Re: Mesa del Sol Tract A - Mixed-use Multifamily DFT Comment Response

The letter outlines the project team's responses to the comments from the May 3, 2023 meeting of the Development Facilitation Team on PR-2023-008551 SI-2023-00778 Site Plan DFT for a mixed-use multifamily development on Mesa del Sol Tract A. The DFT comments are in bold, and the responses are in italics.

**BUILDING A - EXTERIOR ELEVATIONS**

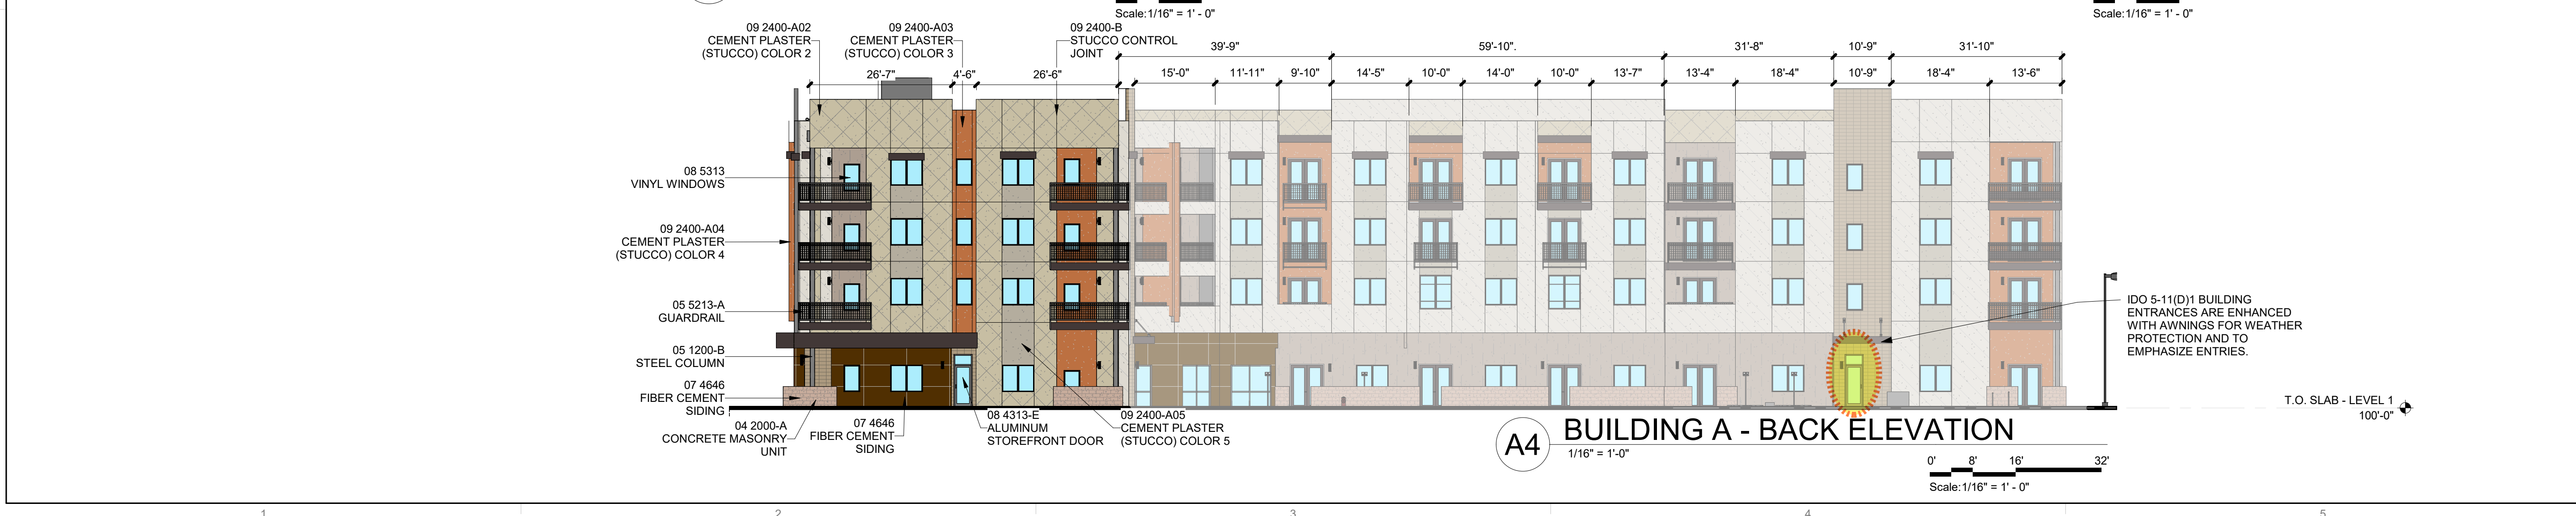
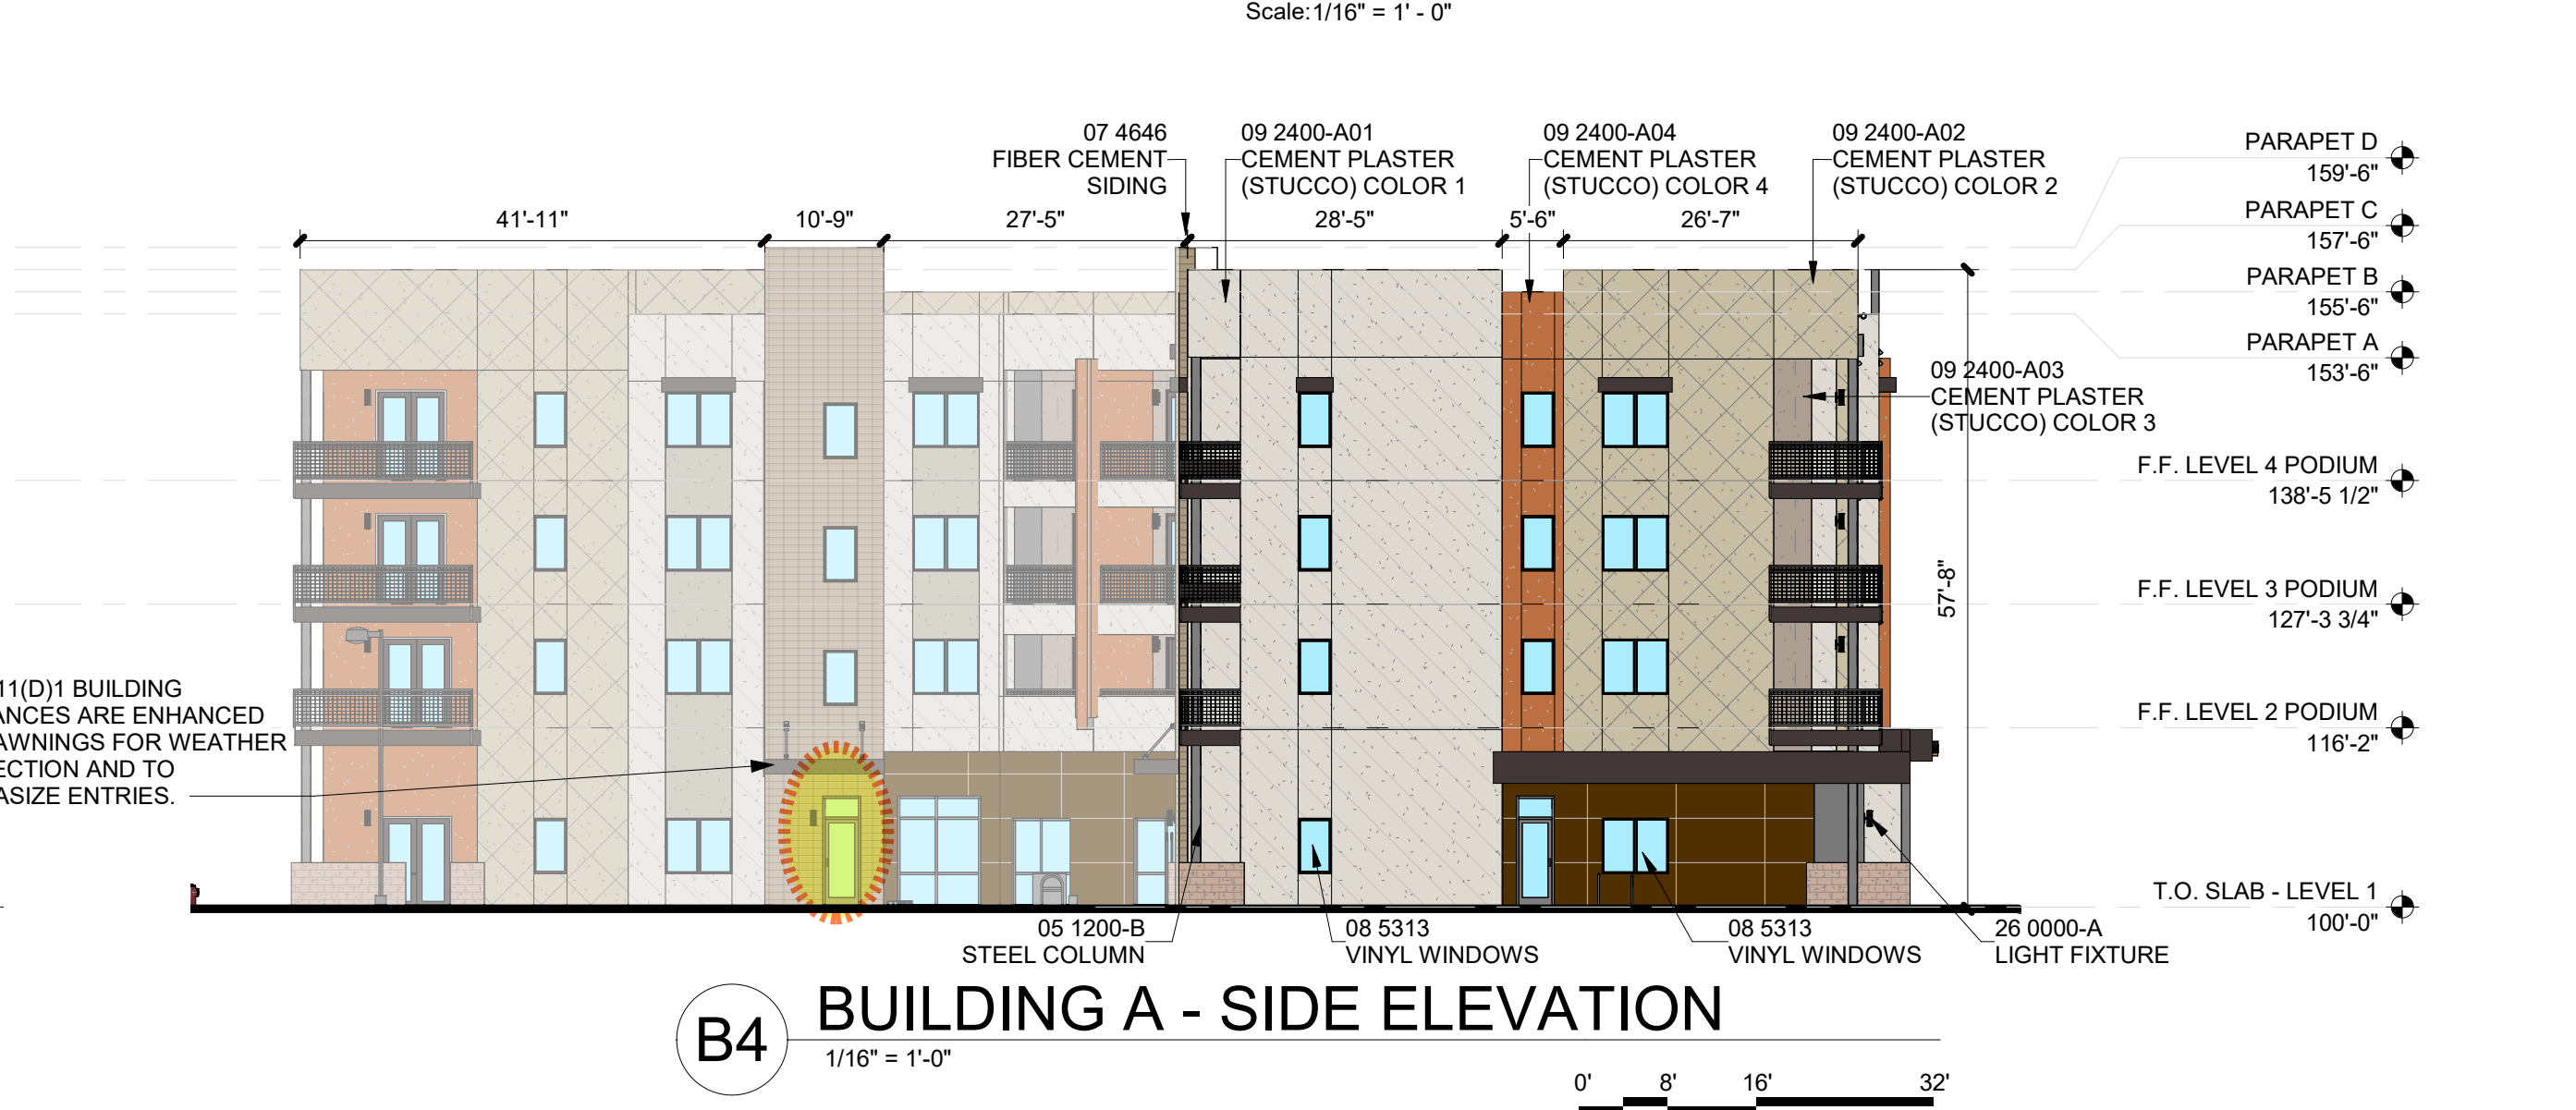
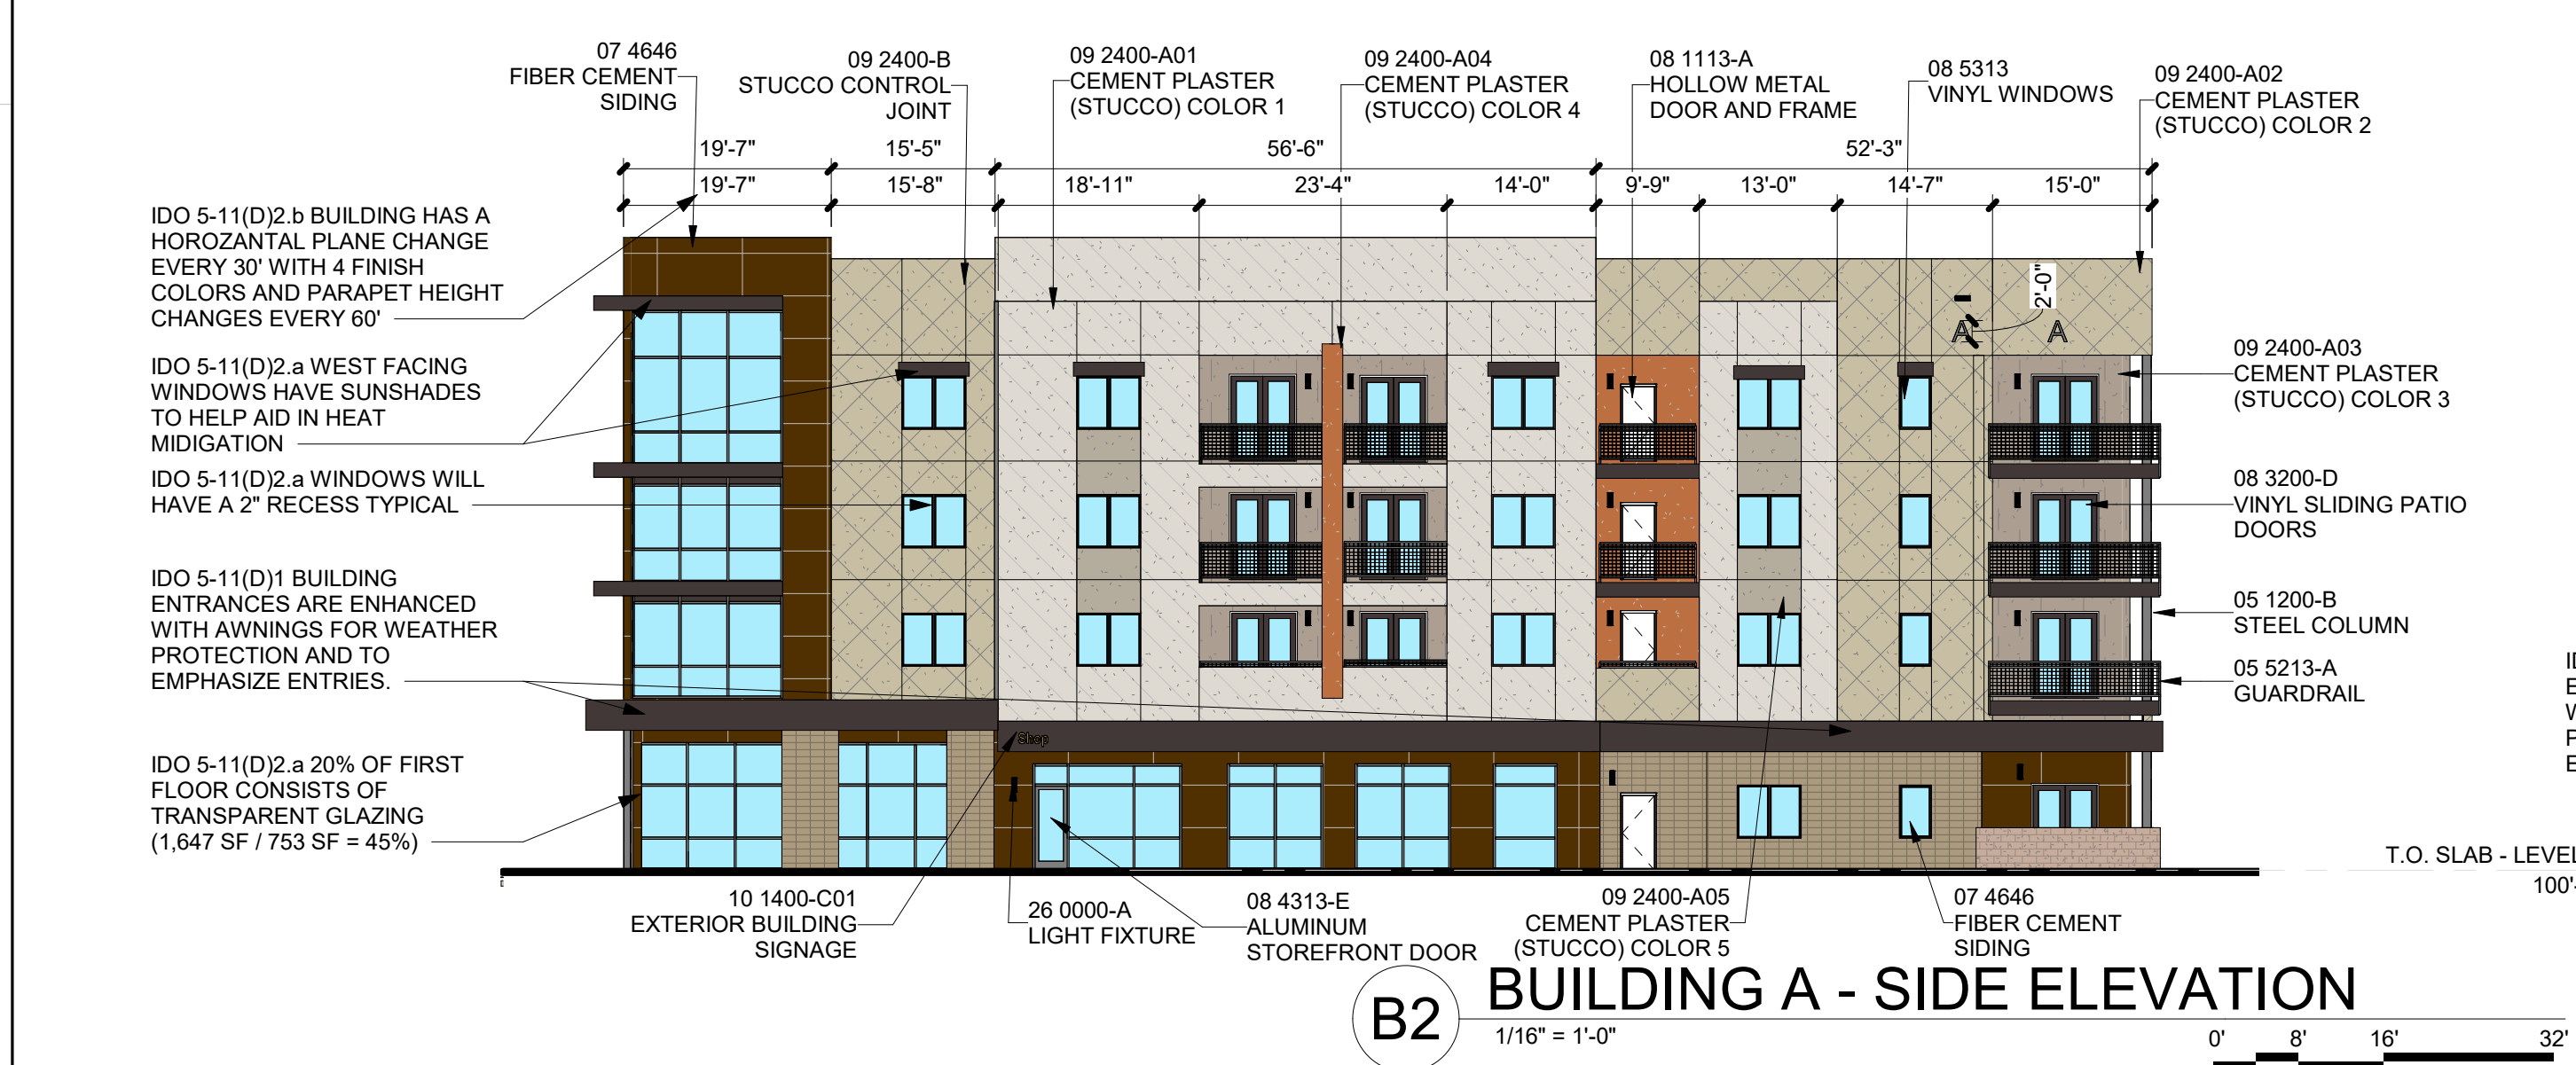
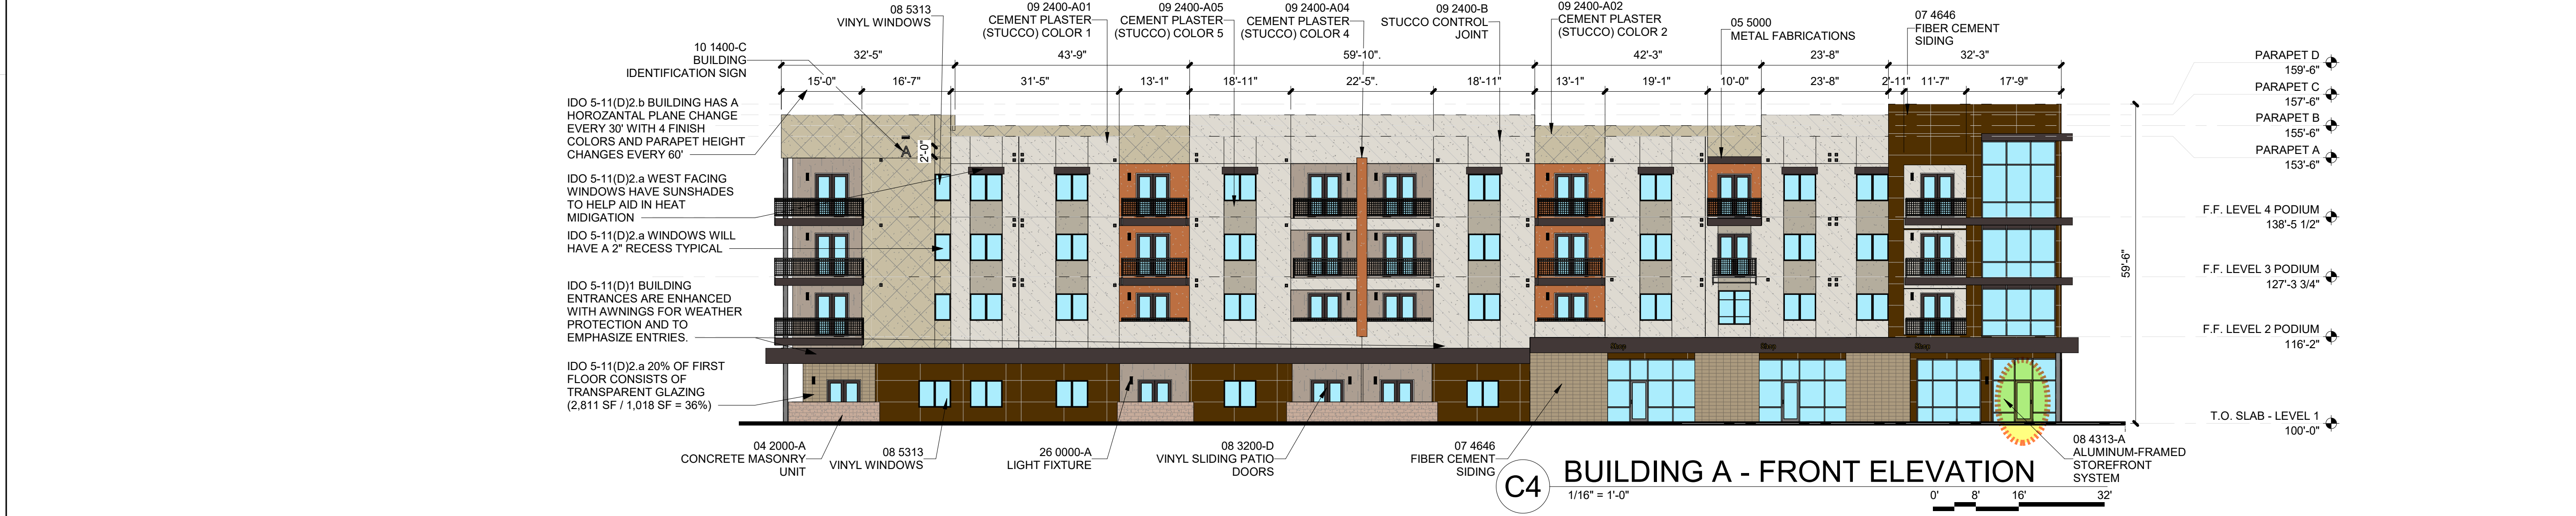
(1) Building Entrances: Show how building entrances are emphasized and provide weather protection. (A, B, D, E, F)

(2) Facades: (a) Windows--

(1) Street-facing ground floor must have 20% in transparent windows.

(2) Windows recessed 2 inches or more must have a 2 inch casing.

(3) West facing windows must use heat mitigation.

(b) Articulation:

(1) One element that is recessed or projected every 30 feet.

(2) Street facing has more than one building finish or color.

(3) Balcony massing, material, or color shall create visual interest.

(3) Roof Design: Any rooflines greater than 60 horizontal feet must have a vertical elevation change of 2 feet.

Building entrances are emphasized by providing windows above the doors. Main building entrances face to the exterior of the side and onto courtyards and are emphasized by recesses and changes in material. The first floor of building A, B, D, E, and F are setback so that the upper floors form an overhang to provide weather protection and a human scale.

Transparent glazing of street-facing facades on the ground floor is detailed on Sheets SDP-5.1-5.5. Buildings A and B have first floor glazing of 45% on the street-facing facades. Building D has first floor glazing of 28% on the street-facing facades. Buildings E and F have first floor glazing of 40% on the street-facing facades. Recessed windows shall be recessed not less than 2 inches and will be surrounded by a casing not less than 2 inches wide as required by IDO Section 5-11(d)(2)(a)2. Windows that face west will use heat mitigation measures including sunshades.

Articulation of the proposed buildings is detailed on Sheets SDP-5.1-5.5. The proposed building elevations include articulation in the form of recesses and projections every 30 feet, variations in color and materials, balconies, and windows. Rooflines include parapets to create visual interest. These parapets meet the requirements of (b)(3) by providing a vertical elevation change of 2 feet for those rooflines that are greater than 60 horizontal feet.
